CITY OF ALBUQUERQUE

April 1, 2020

**Re: Kiddie Academy Westside
Paradise/Nunzio
Traffic Circulation Layout
Architect's Stamp 03-31-2020 (C12-D003A)**

A1 CLEAR SIGHT DISTANCE PLAN

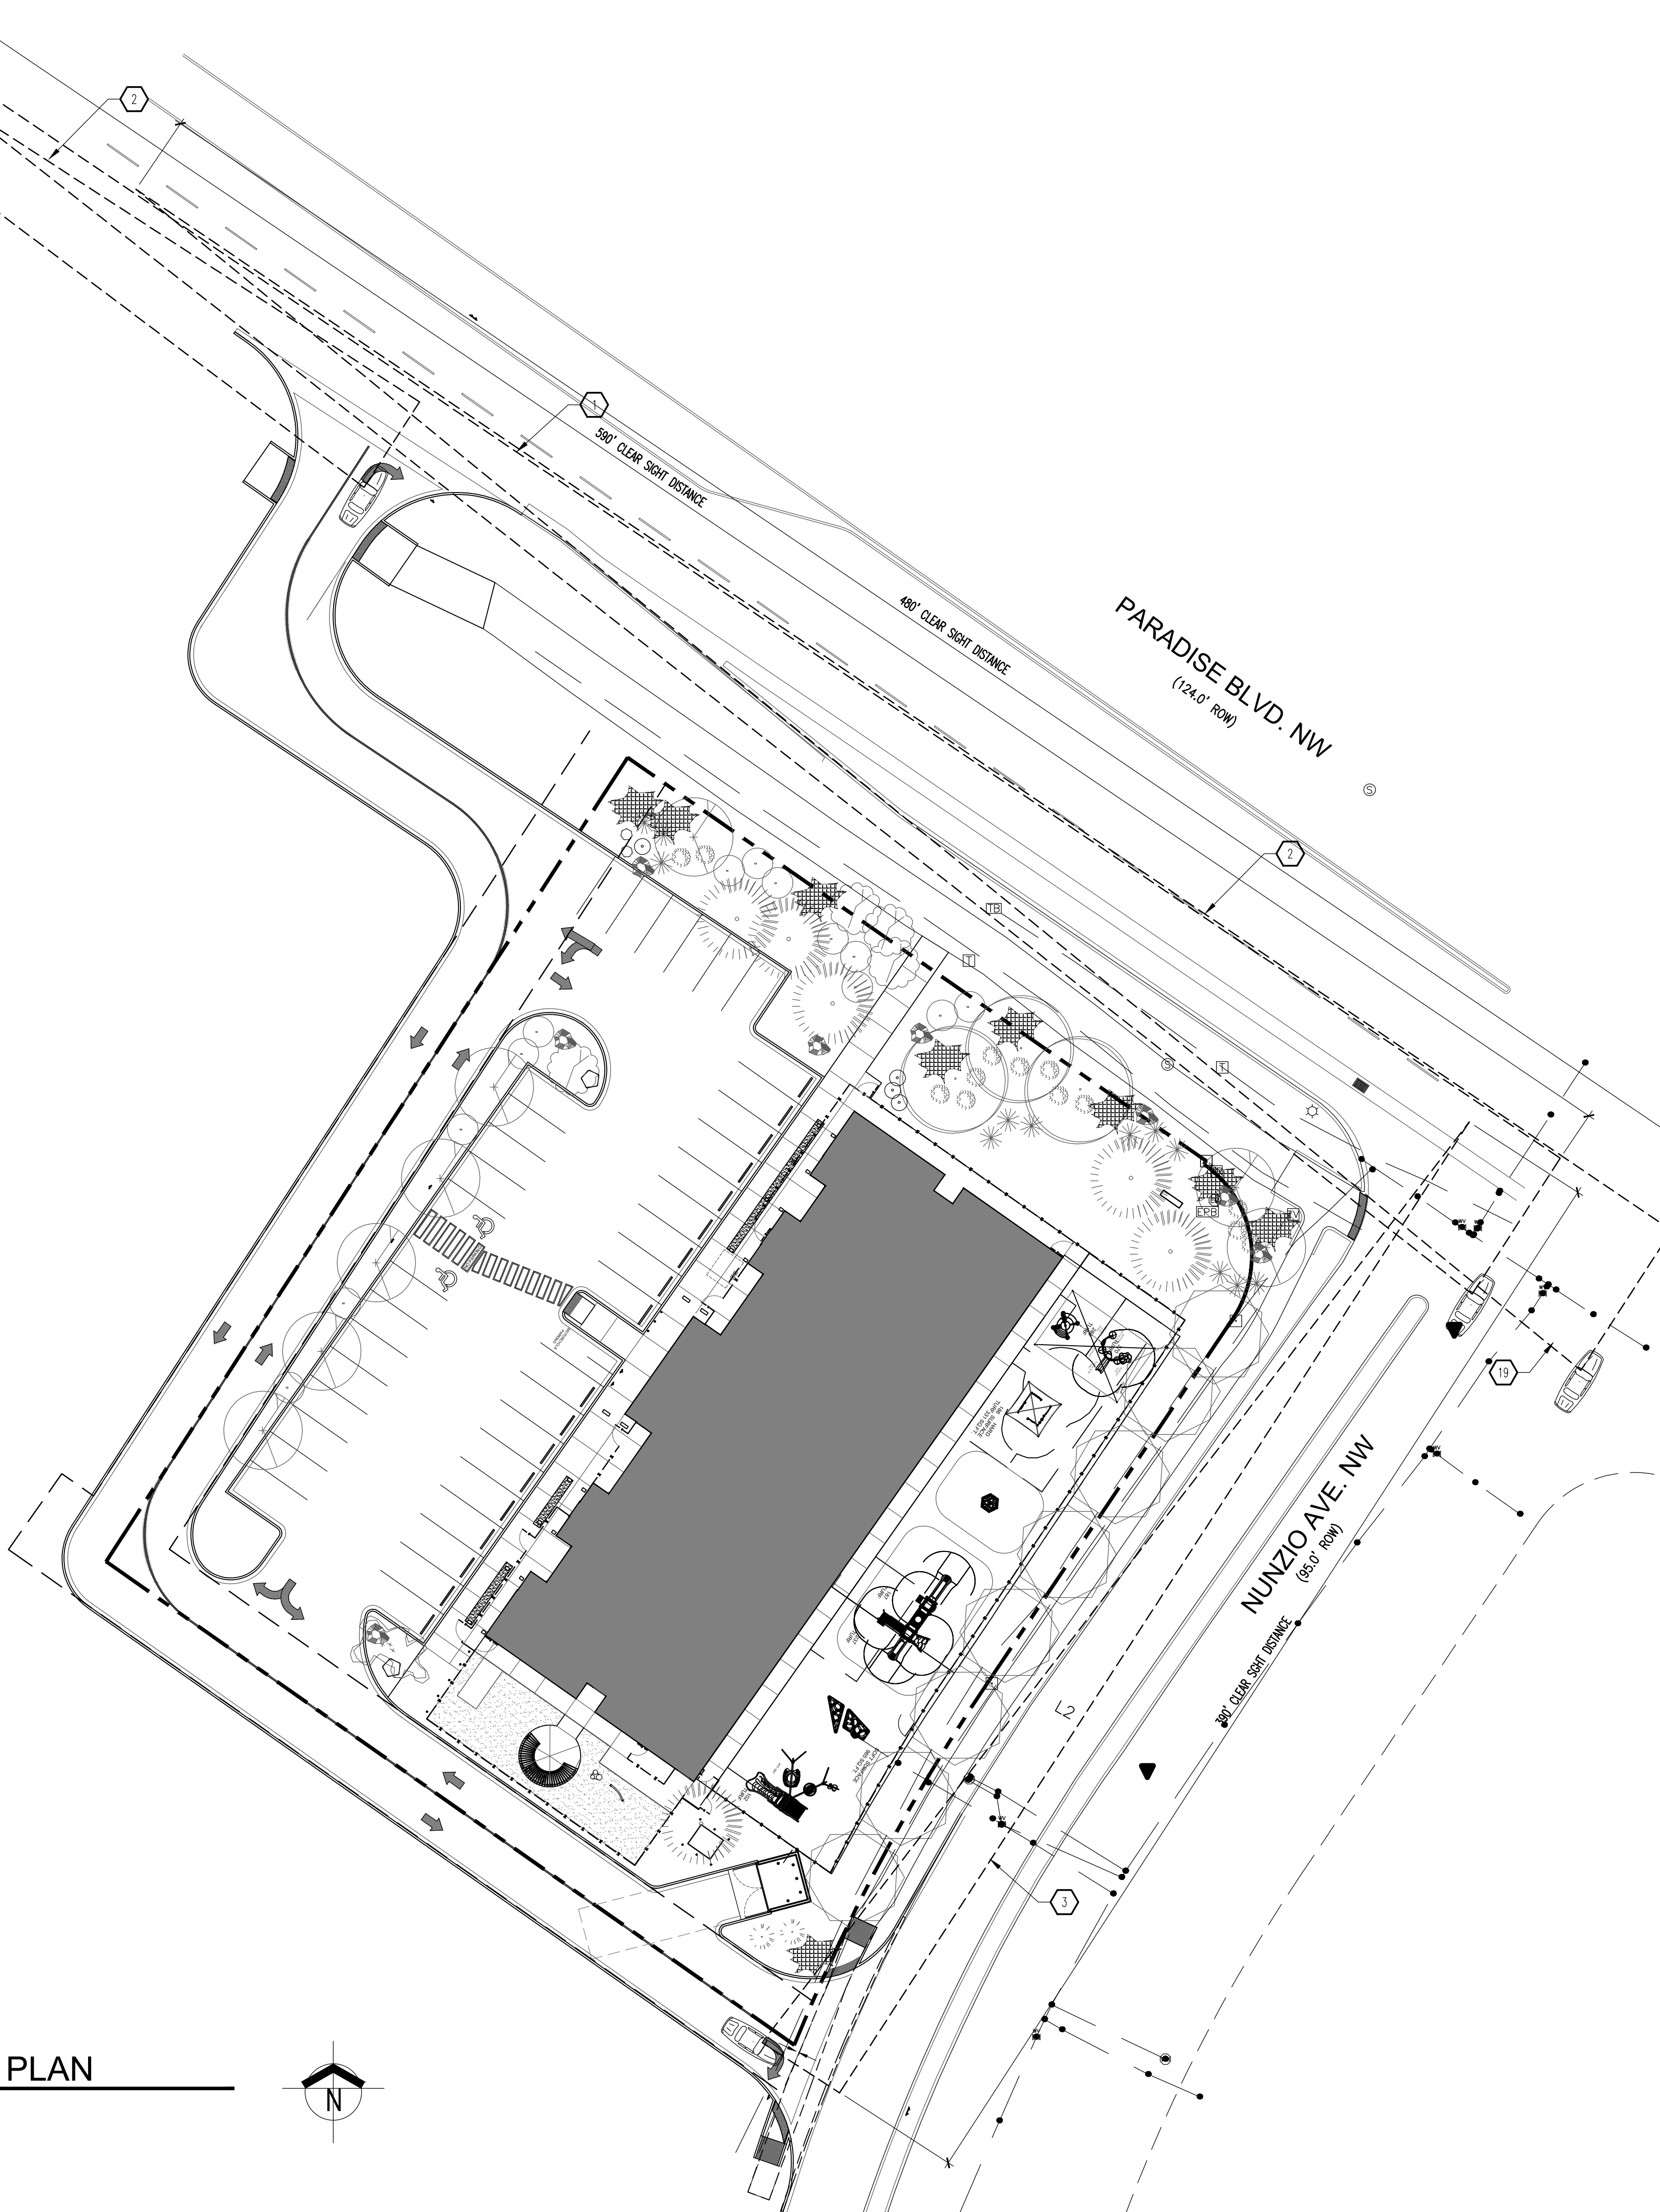
28. Please provide a sight line distance exhibit for the intersection of Paradise and Nunzio with proposed landscaping (see attachment for exhibit).
29. Show the clear sight triangle and add the following note to the plan:
"Landscaping and signage will not interfere with clear sight requirements. Therefore, signs, walls, trees, and shrubbery between 3 and 8 feet tall (as measured from the gutter pan) will not be acceptable in the clear sight triangle.
